Cambridge Waste Water Treatment Plant Relocation Project
Anglian Water Services Limited

Book of Figures – Traffic & Transport

Application Document Reference: 5.3.19
PINS Project Reference: WW010003
APFP Regulation No. 5(2)a

Revision No. 03
8th of March 2024

Figure 19.2

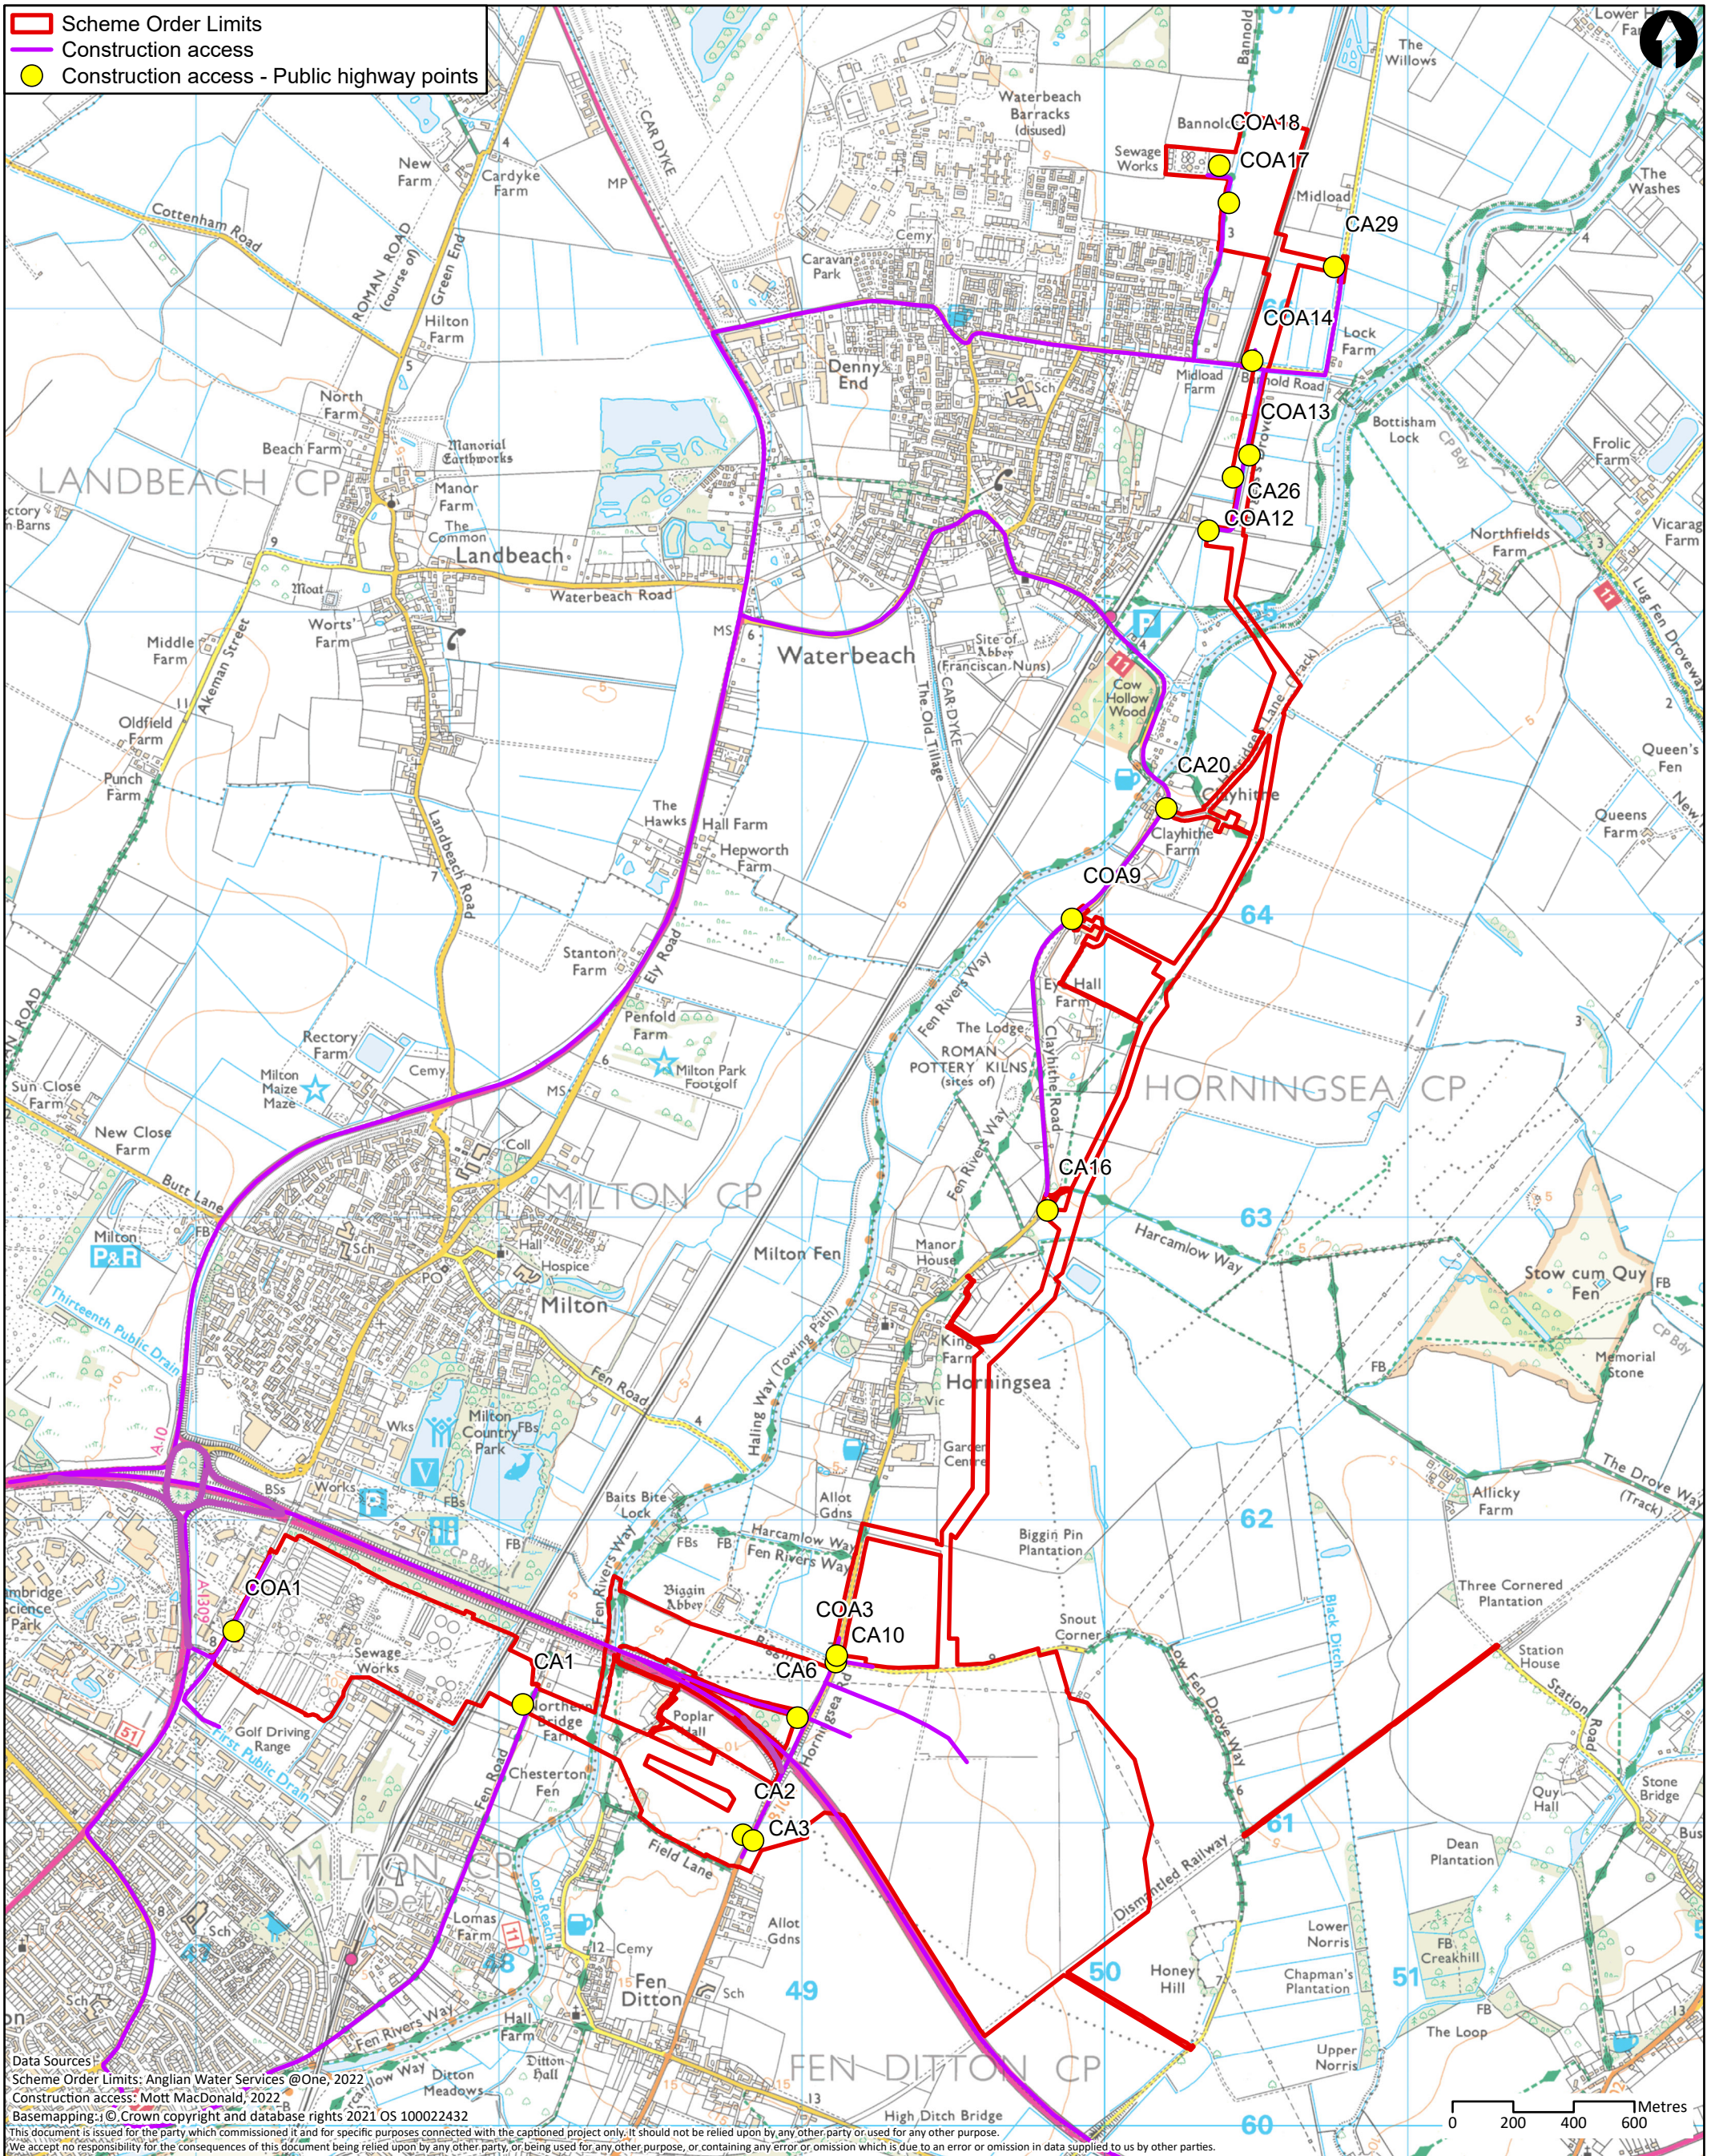
- Figure 19.2 was updated by the Applicant to clarify that the construction traffic access (COA12) for the Waterbeach Pipeline is into the field prior to the entrance to the allotments and does not extend to the railway crossing on Burgress's Drive. This was to provide clarity following comments received from the ExA and a community member on the construction accesses on that section of the Drive.
